Your ref: SSD- 73910208
Our ref: DOC25/678373

Subject: Major Projects – New Request for Advice – Seniors Housing – IRT Woonona Redevelopment (SSD- 73910208) (Wollongong City)

Attachment A – CPHR Detailed Comments – 4-6 Popes Road Woonona IRT redevelopment (SSD- 73910208)

FIGURE F53

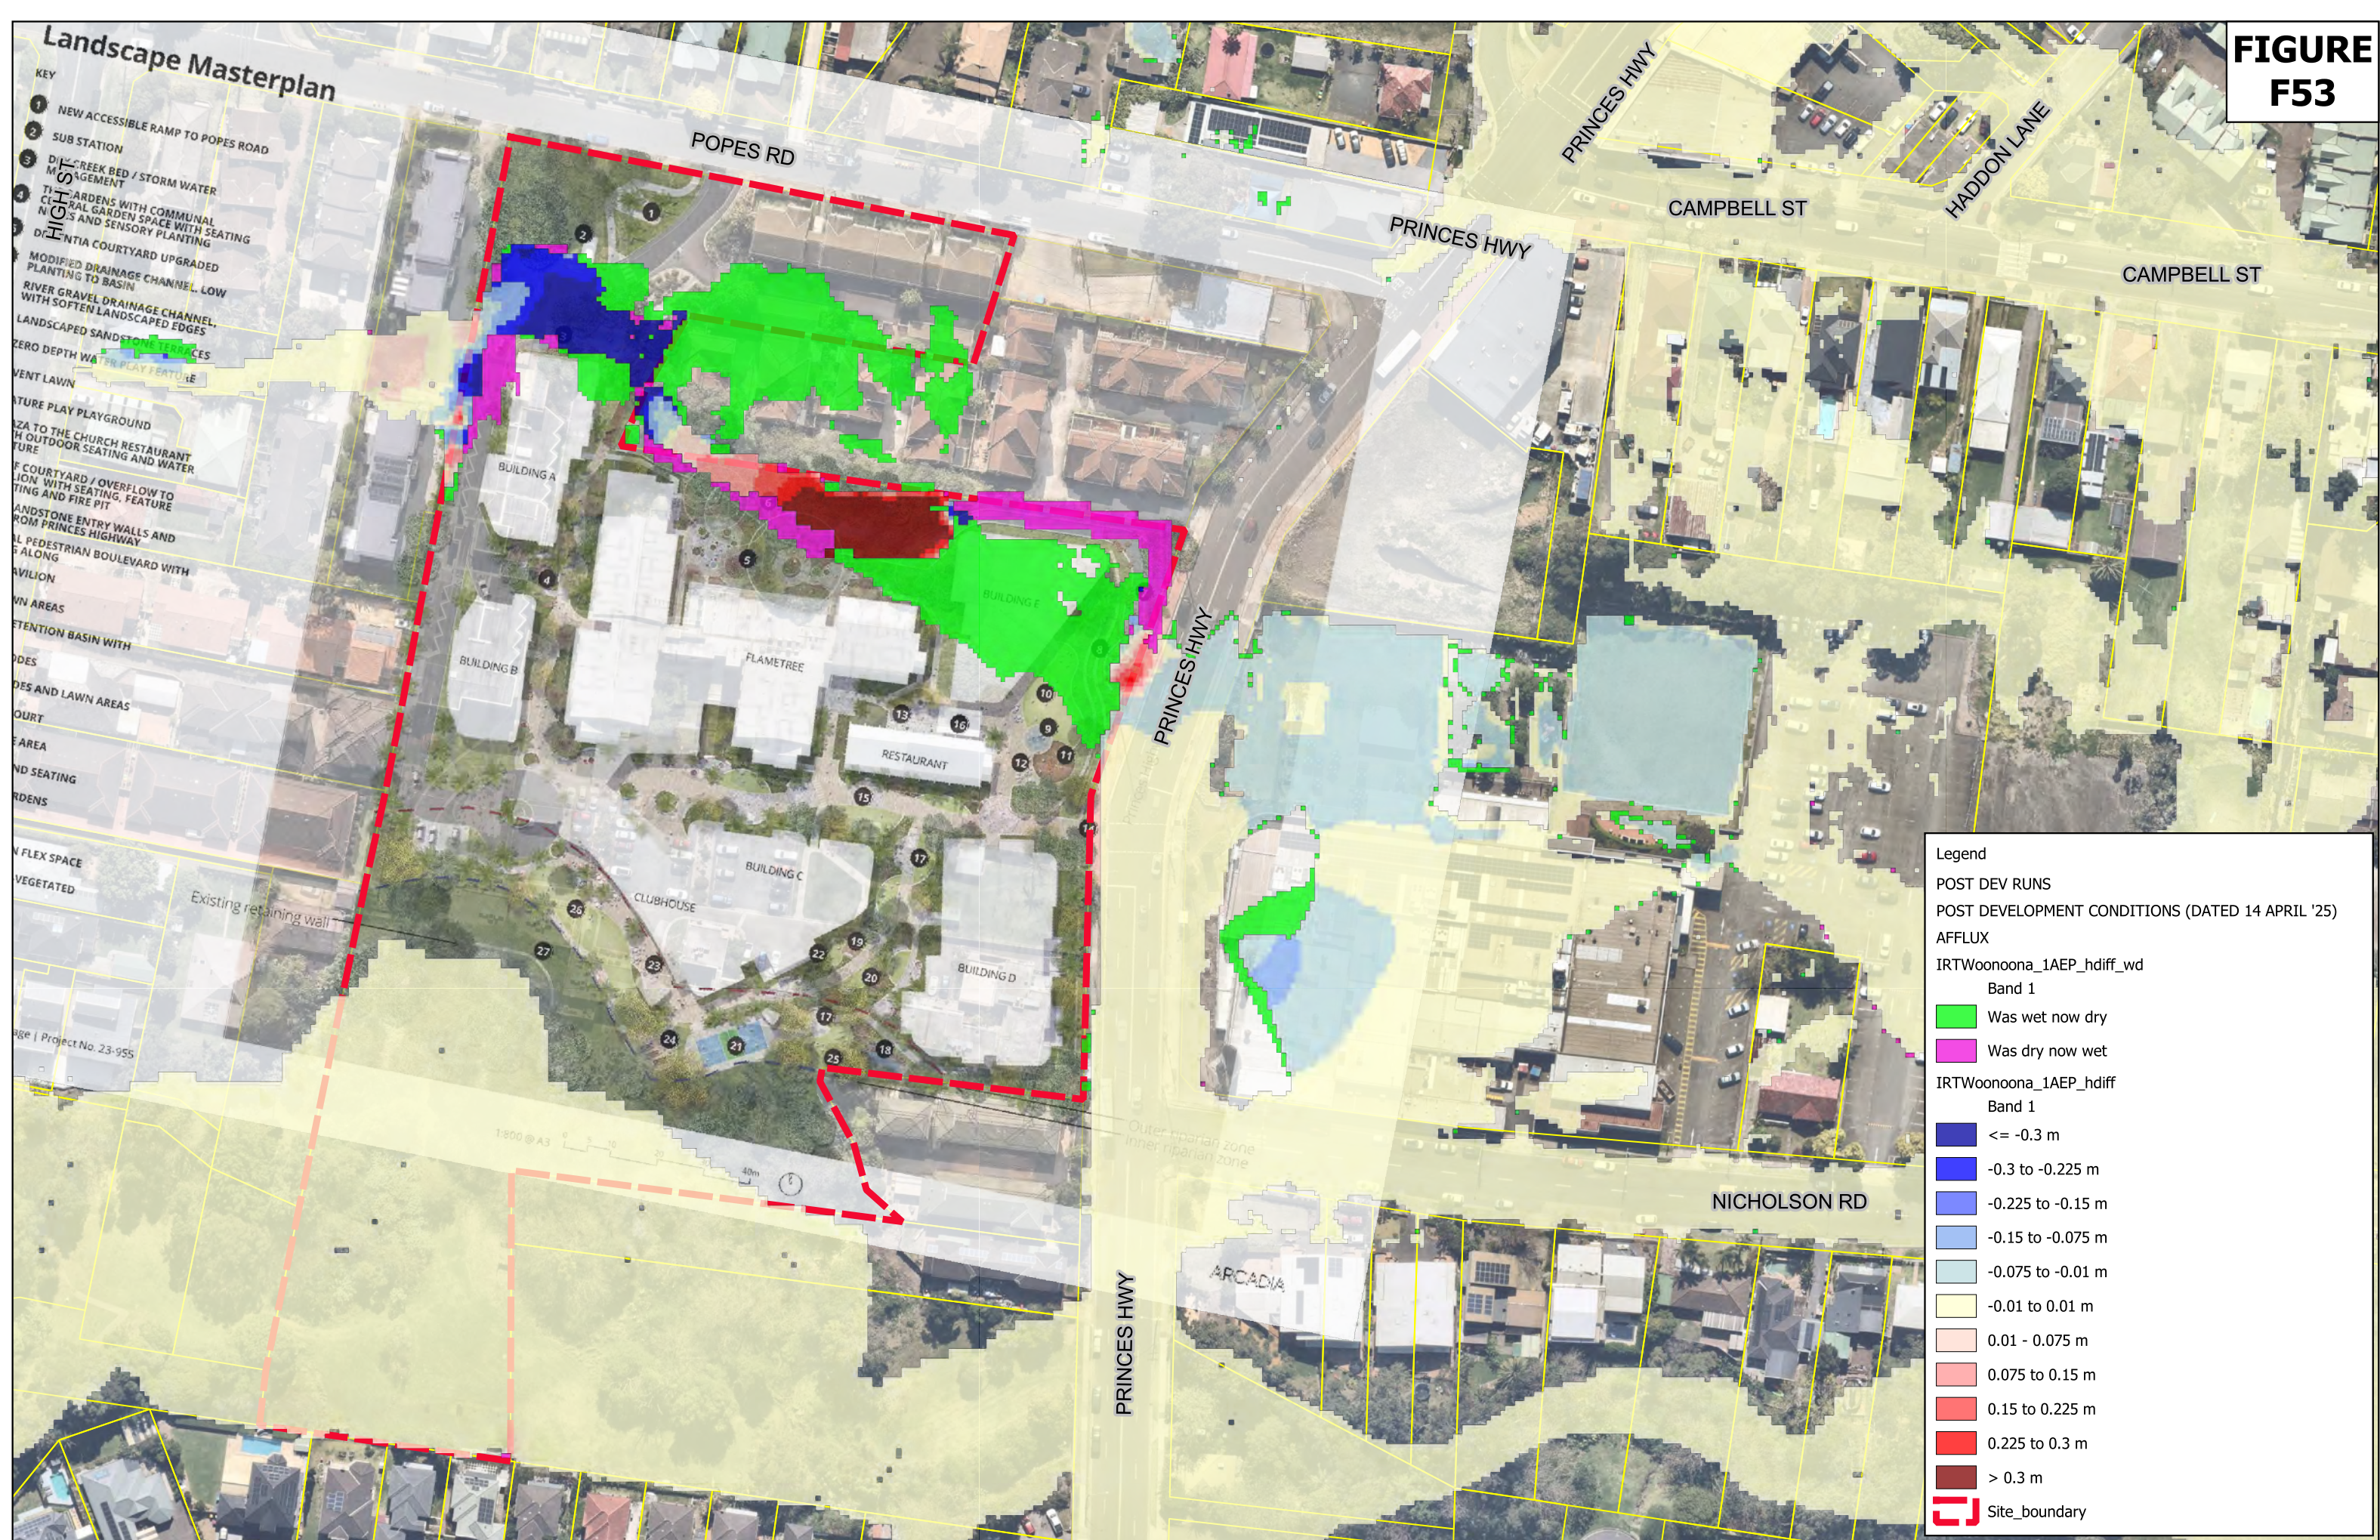
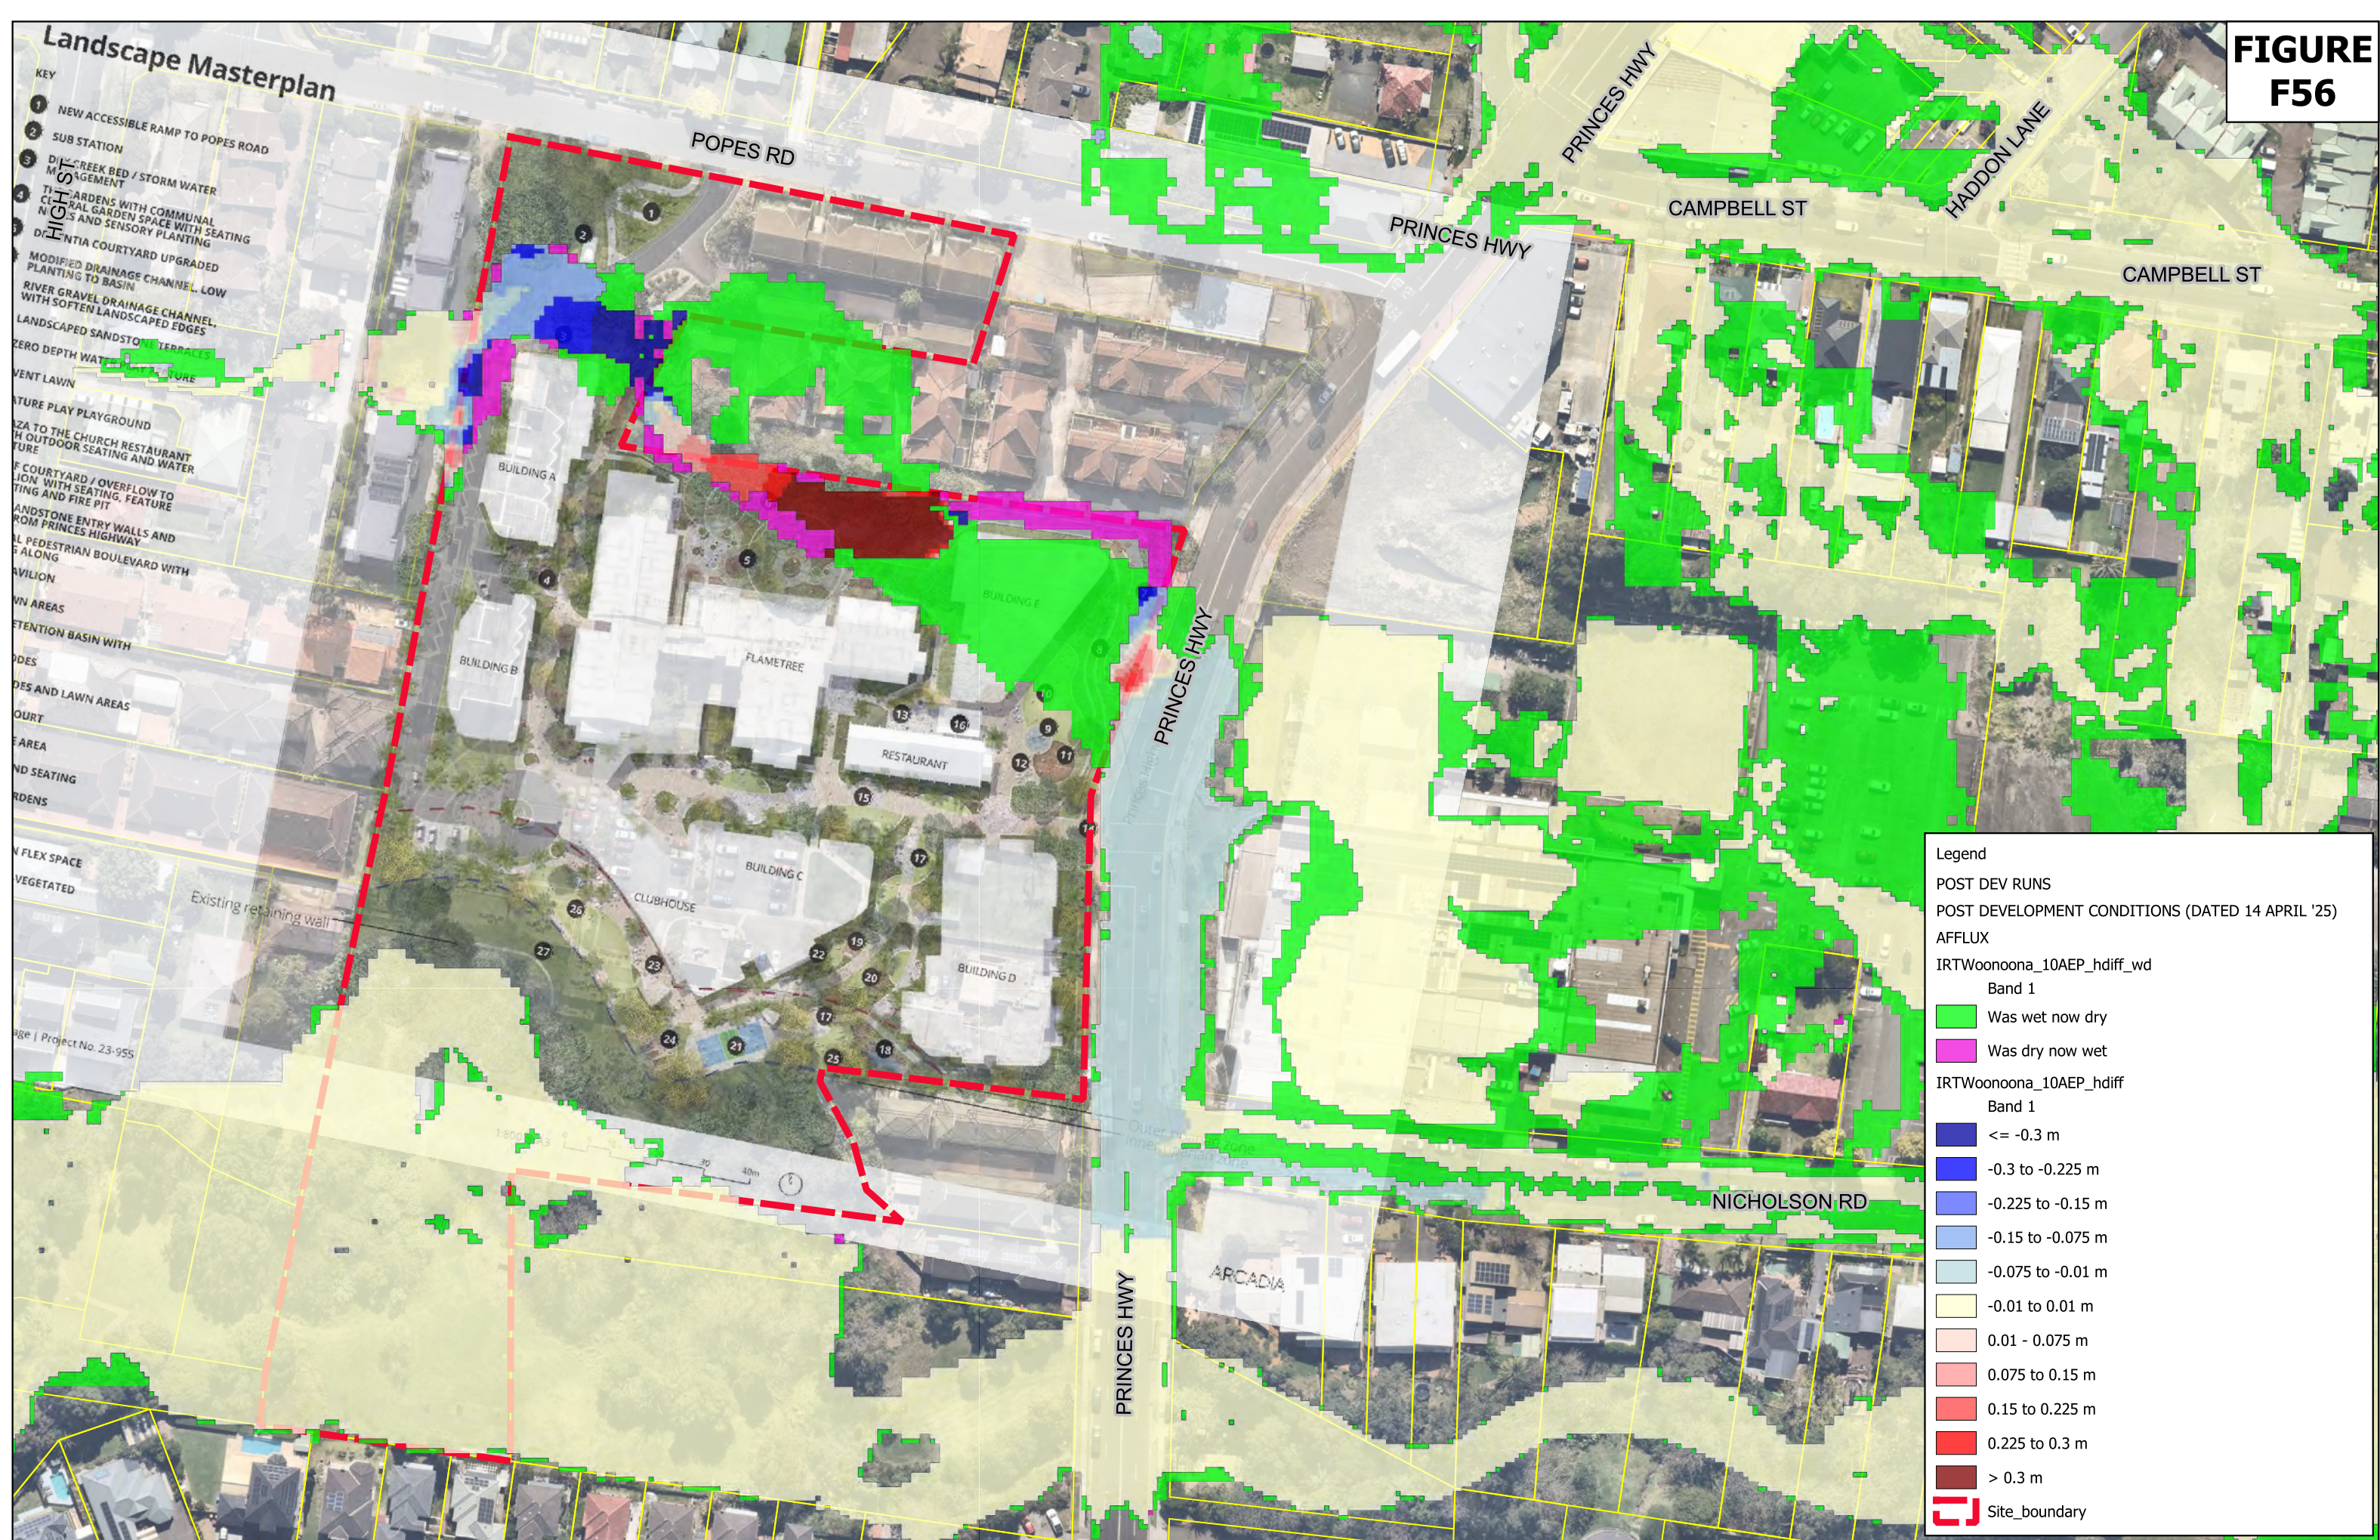
The flood risk impact assessment maps (Figures F53 & F55 to F58) provided in the Flood Report (Acor Consulting, May 2025) identifies adverse flood impacts on Nicholson Road and Collins Creek in the 20% AEP event, and on the Princes Highway from the 10% AEP. The Probable Maximum Flood (PMF) velocity maps (Figures F32 & F61) identify several residential properties along Nicholson Road and the Woonona Bulli RSL Club that were previously not flood affected are shown to be inundated. This information makes it difficult for the determining authority to be satisfied that the adverse offsite flood impacts will be managed on-site. This issue should be resolved including any modifications to the proposed flow paths, flood storage and hydraulic structures (such as the proposed spillway) to ensure that the proposed development does not cause adverse off-site flood impacts and associated liabilities whilst still meeting its intended flood design outcomes for the new development.

As Wollongong City Council (council) is the local authority responsible for flood risk management and holds the most up to date flood information at this site, it is recommended that they be consulted to ensure that the adverse impact assessment issues identified above aligns with the requirements of council's flood related development controls. This should include managing adverse flood and stormwater impacts and flood related public safety requirements. It is noted that the Flood Report concludes that the PMF with a freeboard will be used as the Flood Planning Level (FPL) to meet council's development controls. Whilst this avoids the need for evacuation of vulnerable residents, the Flood Report should still establish that the proposed FPL is greater than the Design Flood Event, which is the 1% AEP plus climate change currently required by council.
